# City of Albuquerque Stormwater Construction Site Inspection Report

Project Name:	Ceja Vista Ph 1'				
Location:	Dennis Chavez & 98th St				
Site Contact Name & Agency	Allen William - Ceja Vista llc	ESC File No.	P09E002D_CV		
	<a href="mailto:ballen@westpacnm.com">ballen@westpacnm.com</a>	NPDES Id. No.	NMR1002BE		
Inspection Date:	09/11/19	Start/End Time:	0920/0925hrs		
CoA Stormwater Inspector:	Timothy E. Sims				
Construction Phase:	clear & grub				
Type of Inspection:	<input checked="" type="checkbox"/> Regular	<input type="checkbox"/> Storm Event	<input type="checkbox"/> Post Storm Event >0.25"	<input type="checkbox"/> 311/Complaint	<input type="checkbox"/> Follow Up

RECEIVING WATERS: UNNAMED POND	
CRITICAL HABITAT: CRITERION "A"; NO CRITICAL HABITATS WITHIN PROJECT AREA	
GPS LOCATION: 35.0235, -106.7402	
CEJA VISTA	
PROJECT TITLE	
ALBUQUERQUE, BERNALILLO COUNTY, NM	
CITY, COUNTY, STATE	
REV 09/03/2019	DATE
C. DURKIN	DRAWN BY

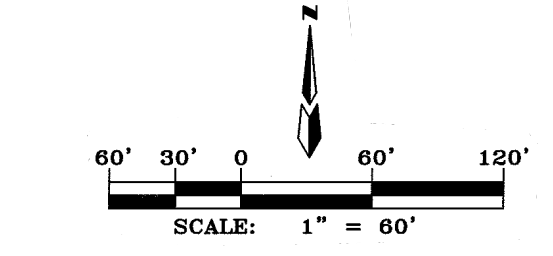
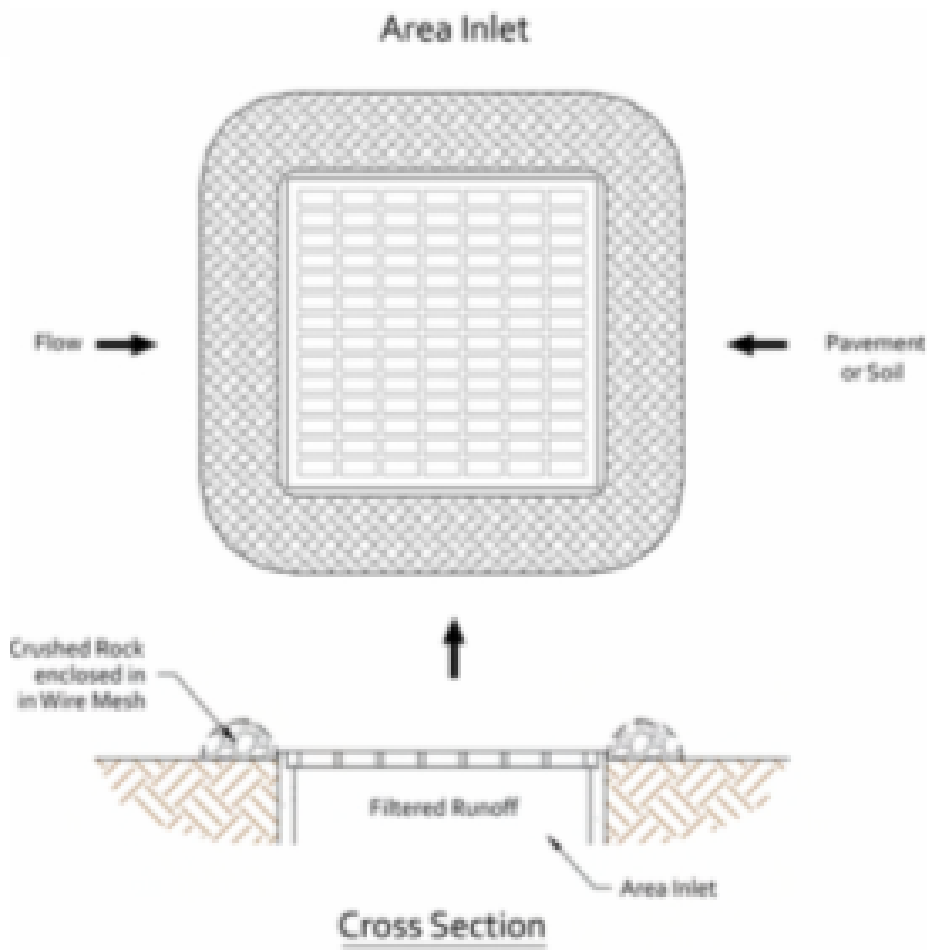
Item Number	Deficiency/ Corrective Action			
	no issues observed with this inspection			
	***it is recommended at this time to install BMP's per approved plan.			
	**Please provide latest SWPPP self-inspection report.			
2.1	Discharge off site? (Y/N)	No		
4	Self Inspection Reports	requested	Latest report Date:	none on file
